**United Utilities Water Limited
Developer Services & Metering**
2nd Floor, Grasmere House
Lingley Mere Business Park
Lingley Green Avenue
Warrington
WA5 3LP

Your ref: 3/2020/0332
Our ref: DC/20/1771
Date: 01-JUN-20

Location: Land off Sheepfold Crescent Barrow BB7 9XR
Proposal: appearance, landscaping, layout and scale following outline planning permission 3/2018/0910

Client	LEA HOUGH & COMPANY LTD.
Job title	BARROW BROOK WHALLEY
Drawing title	DRAINAGE STRATEGY PLAN
Date	1/5/20
Scale	6:120
Drawing No	20046/01/1
Rev	A

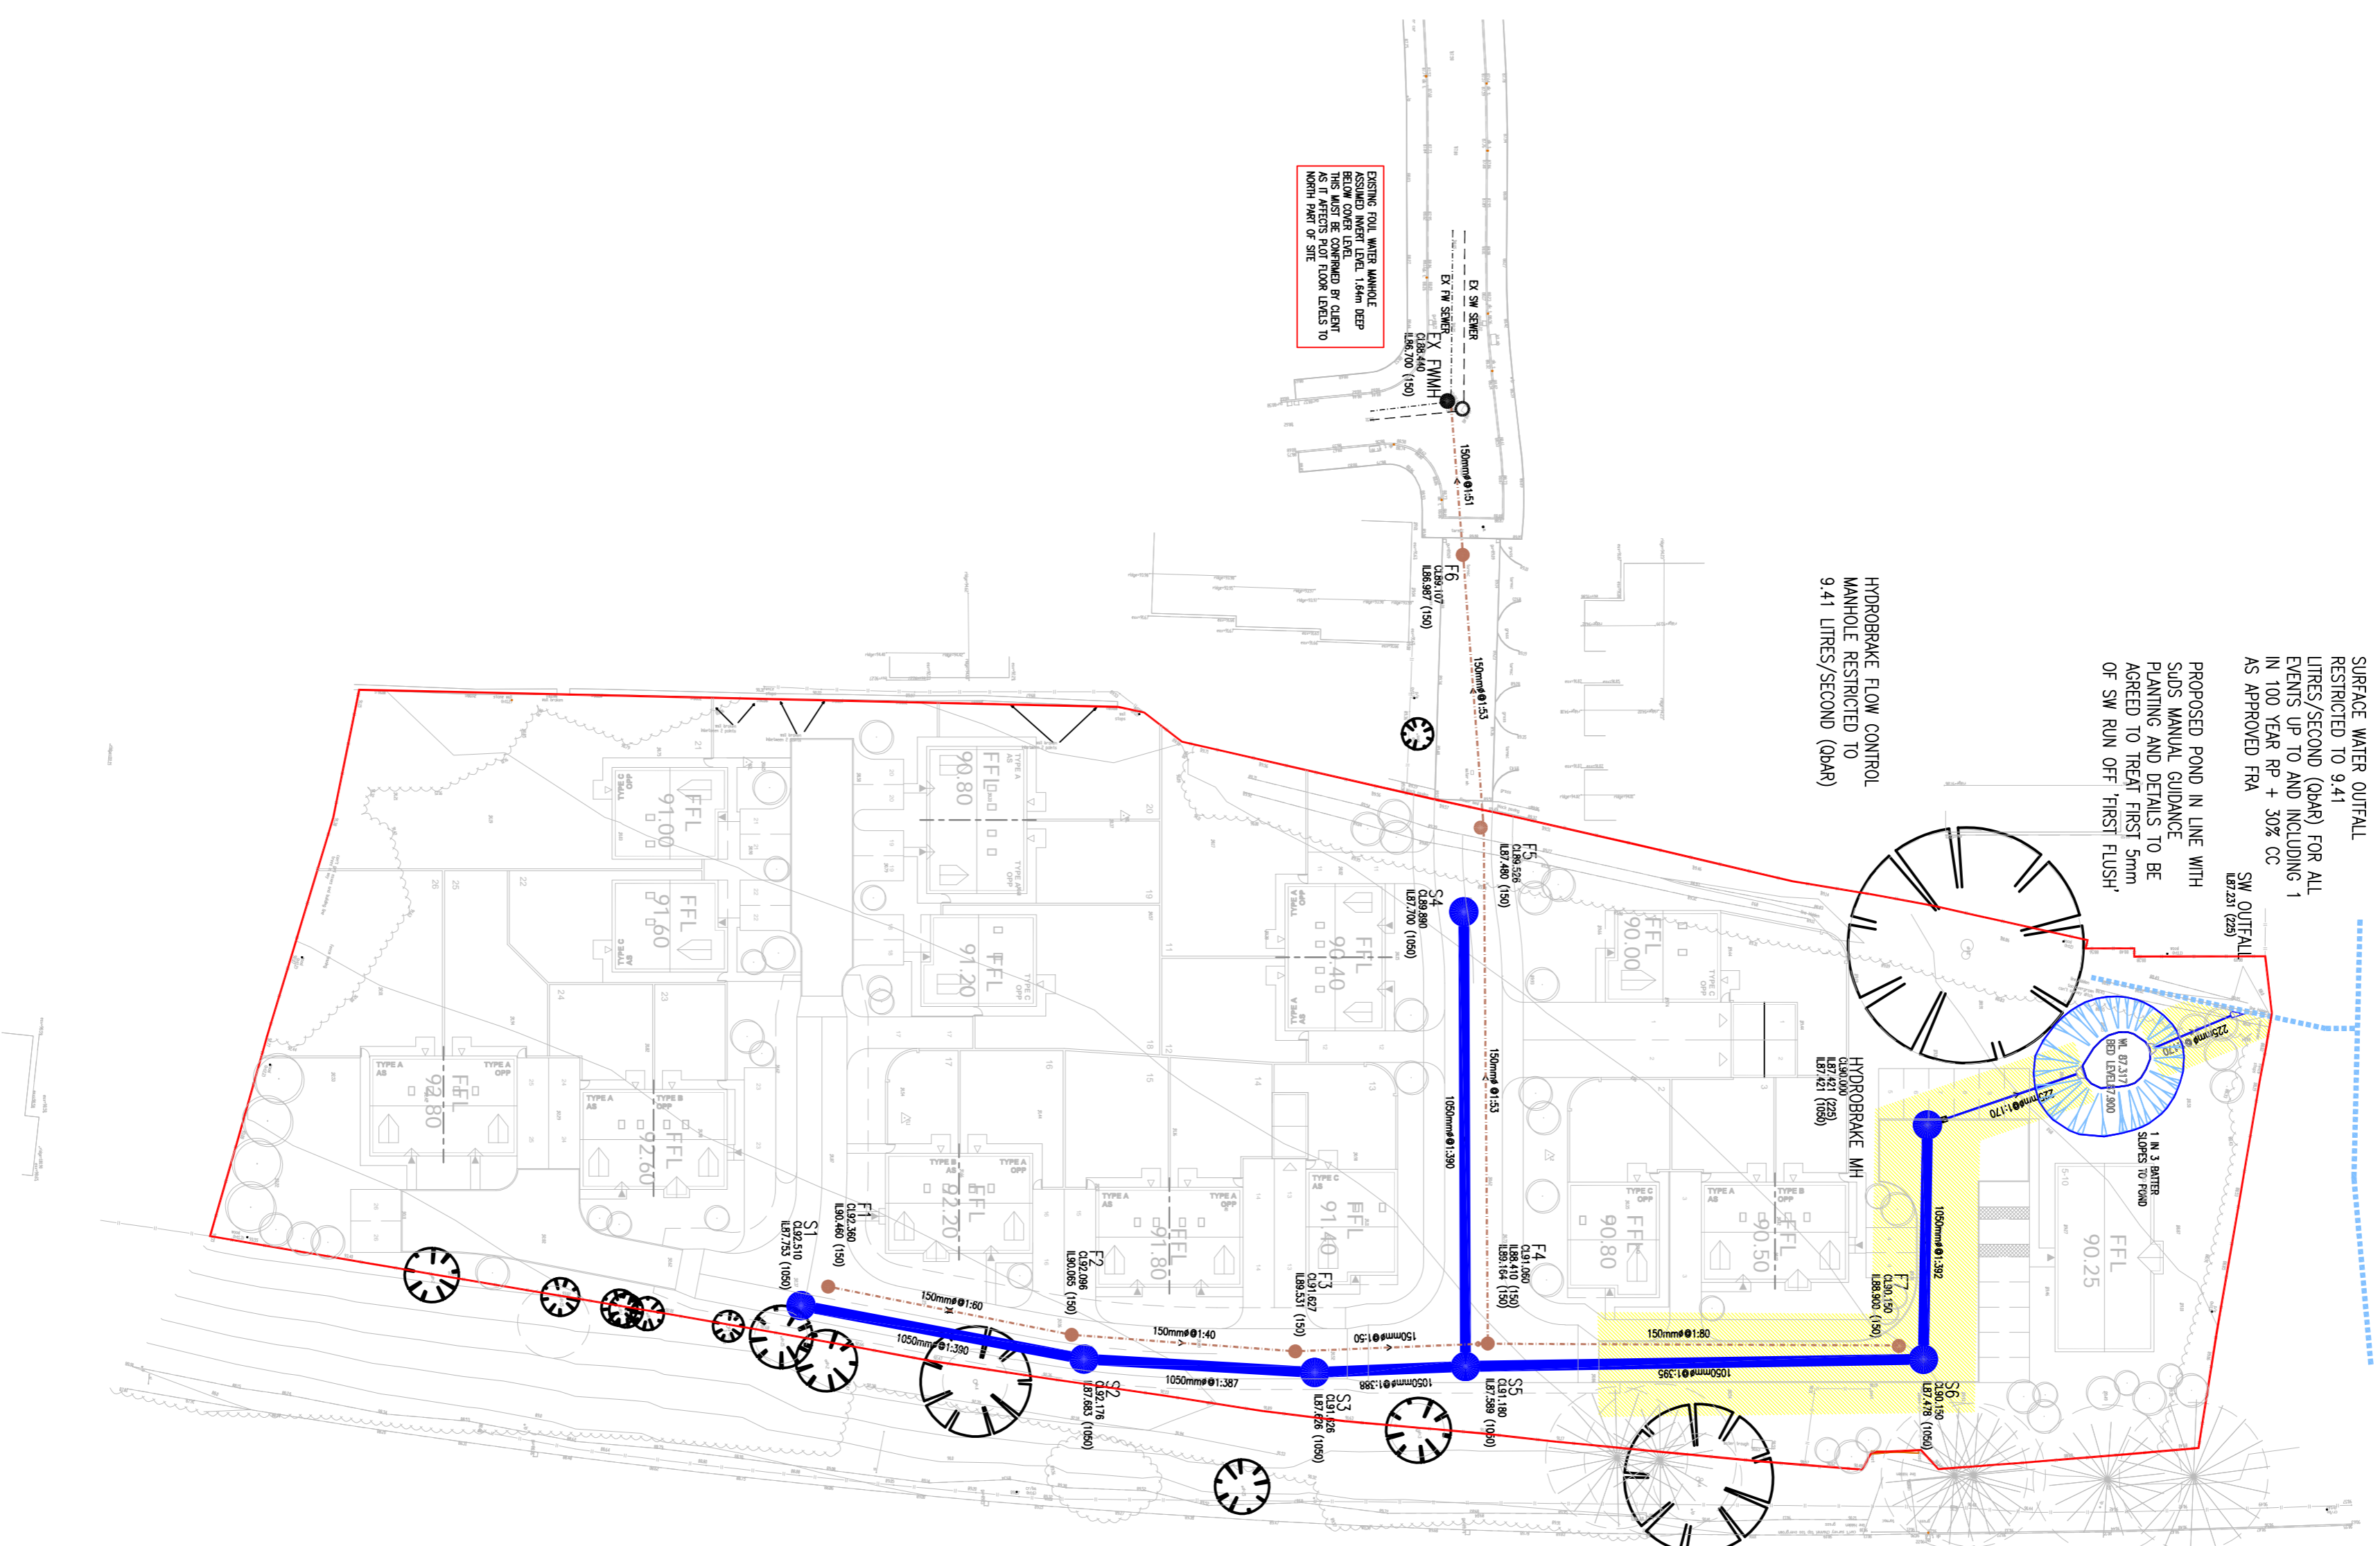
Further to our review of the submitted Drainage Strategy Plan, prepared by: REFA, Ref: 20046/01/1, Rev: A, Dated: 15.04.2020, the plans are acceptable in principle to United Utilities
